**RE: Evans Park PRD, 17909 25<sup>th</sup> Ave NE  
1<sup>st</sup> technical review comment response letter  
Permit #: PA22-003**

Please refer to our responses below which address all review comments received from you via email on April 11, 2022. You will find the markup comments listed in the order that they were written followed by our response in *italics*.

A PORTION OF THE NW 1/4 OF THE SW 1/4 OF SEC 20, TWN 31 N, RGE 5 E, W.M., SNOHOMISH COUNTY, WASHINGTON

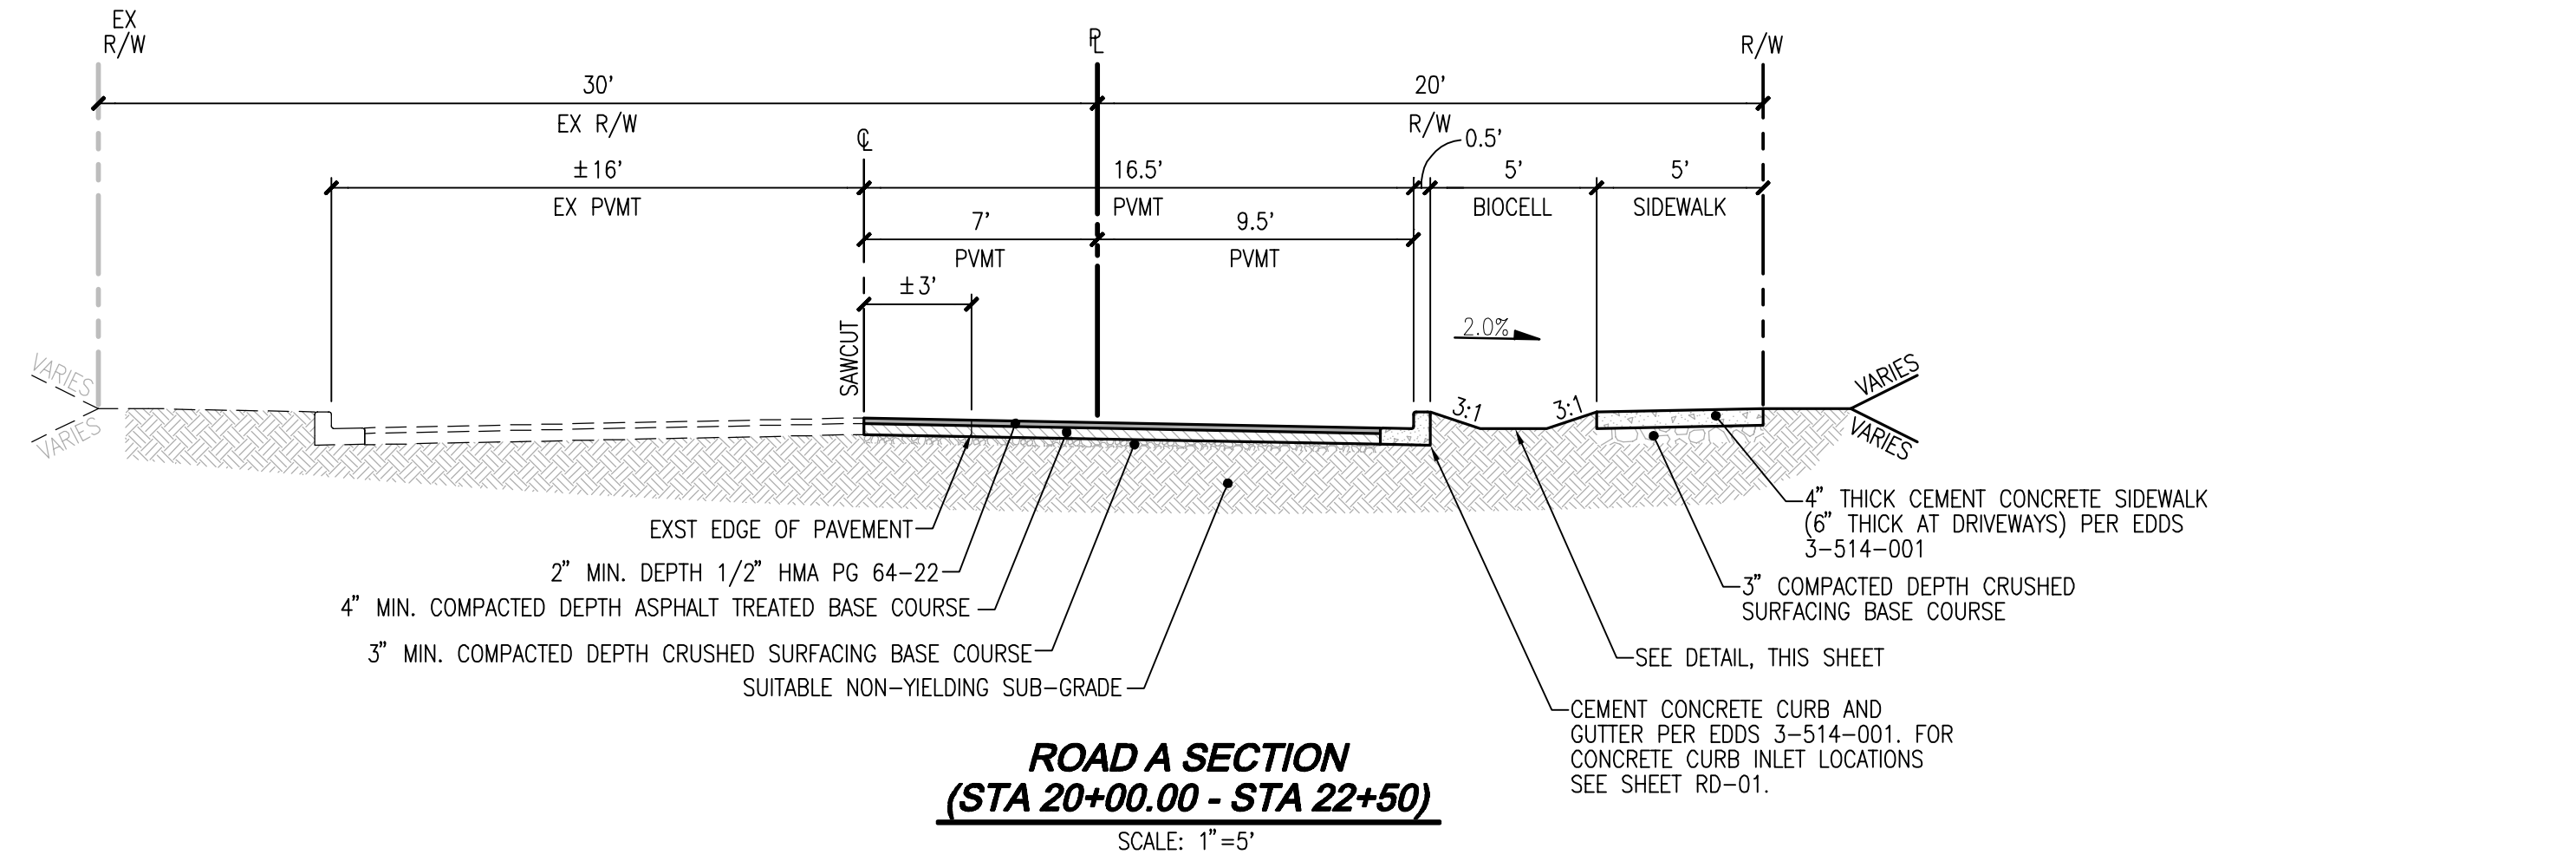
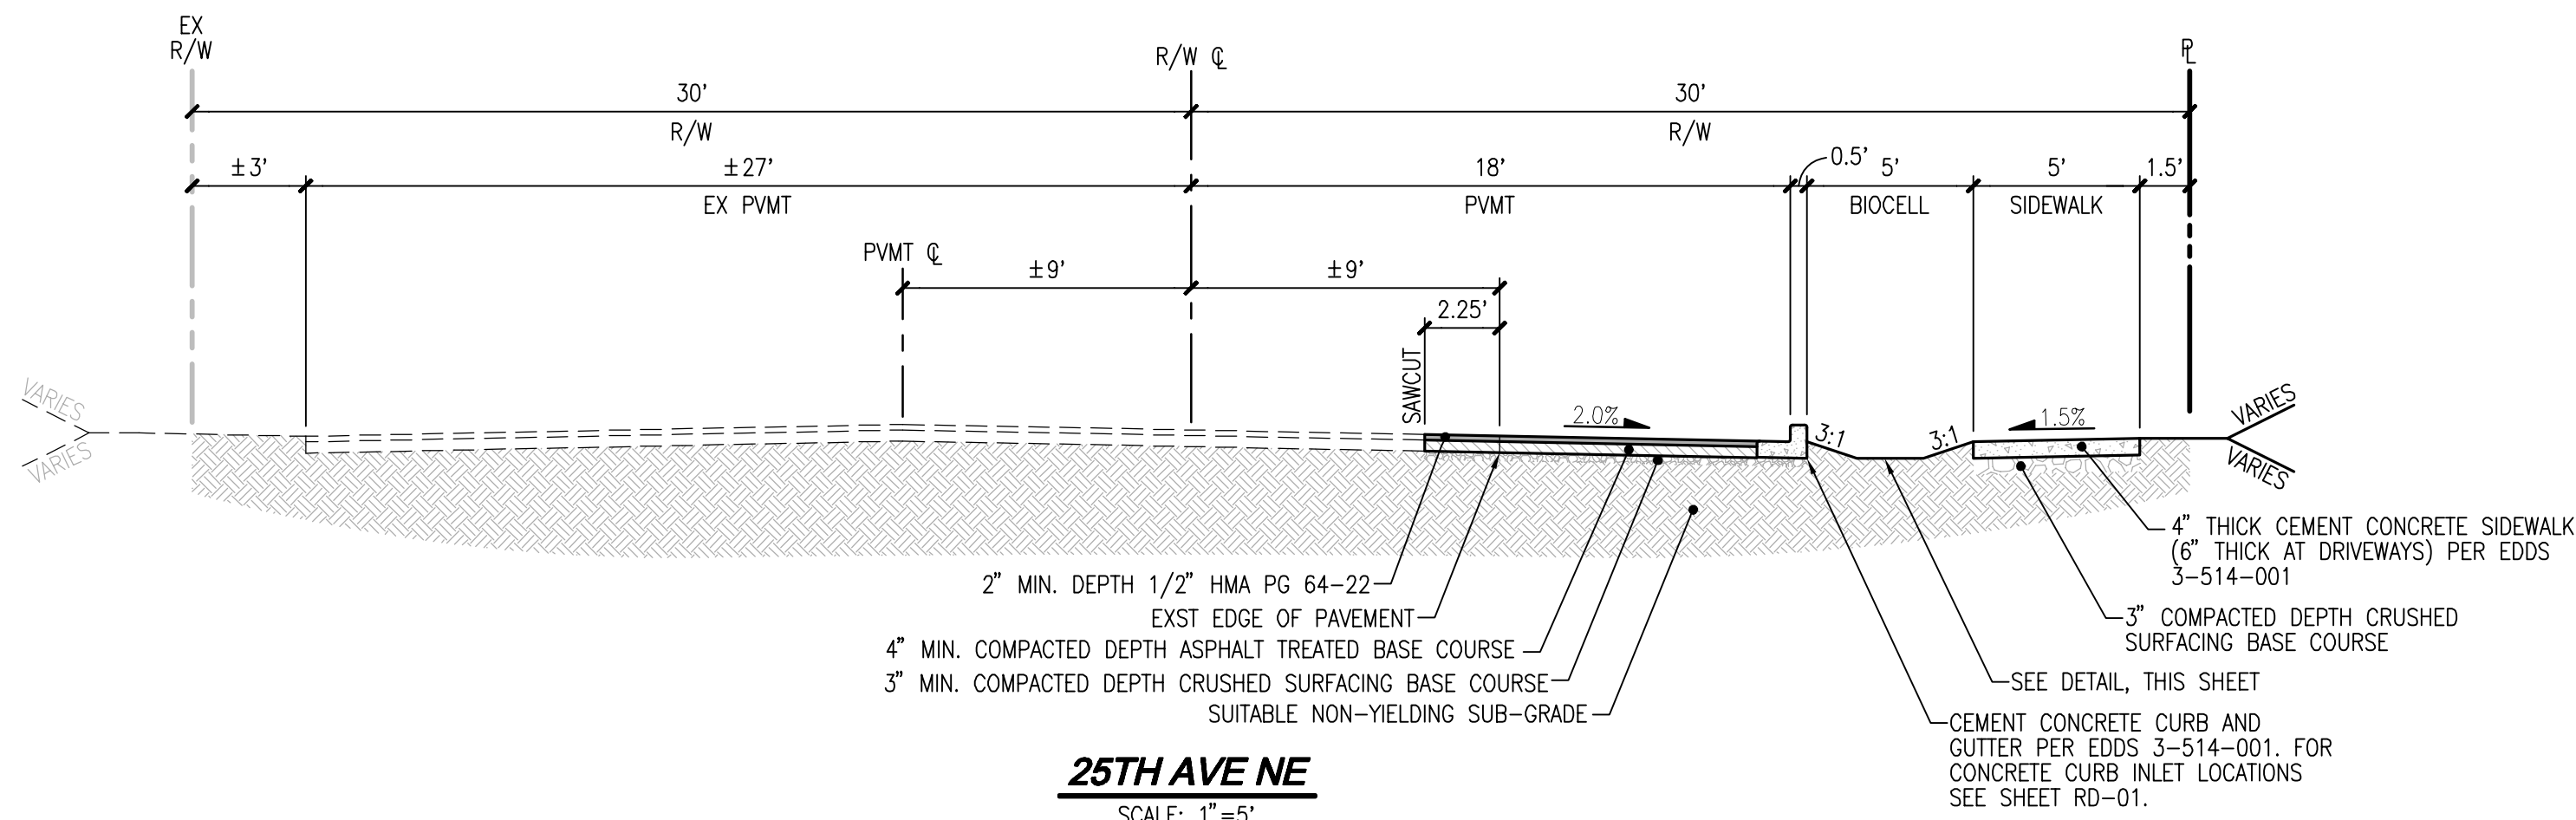
- a. It doesn't appear that a variance was submitted for the planter strip along Road A, regardless a full 5' planter along the entire street will be required

**Response: The Road A section has been revised to show a 5' planter and ROW**

***dedication and lot depth have been adjusted accordingly.***
